Application for a Non-Material Amendment Following a Grant of Planning Permission

Single storey side extension with the addition of a rooflight. Internal remodel to the ground floor.

APP/23/00086/F

DRAWING N°: ARK.MAR.106 **REV:** 2

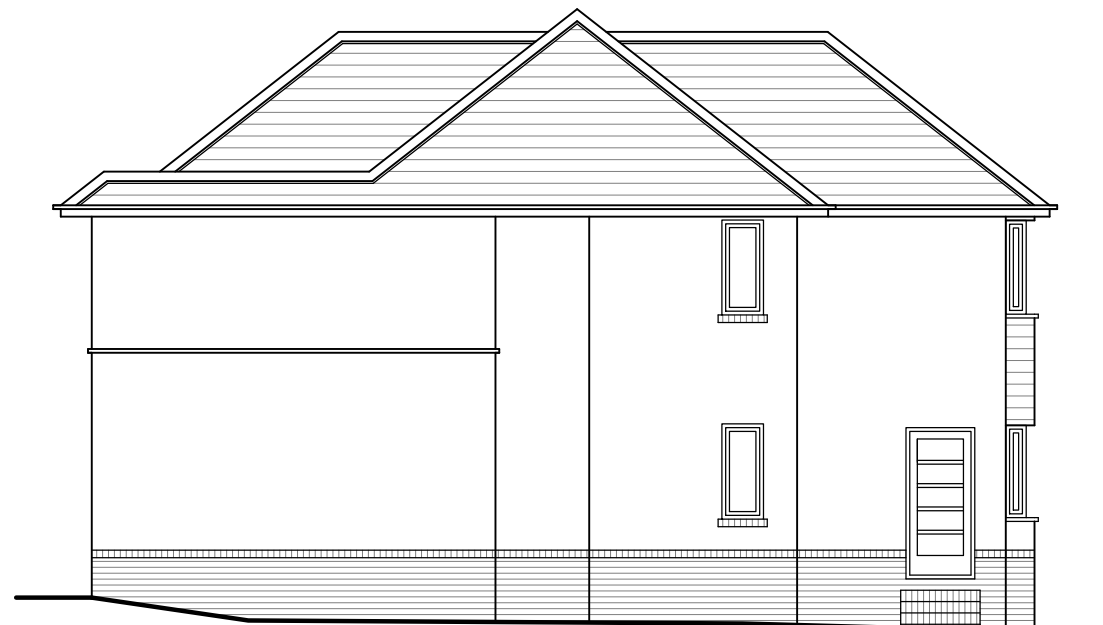
proposed original extension roof was to be hipped to flat roof.

This NMA seeks permission to change the extension roof to be flat roof with parapet.
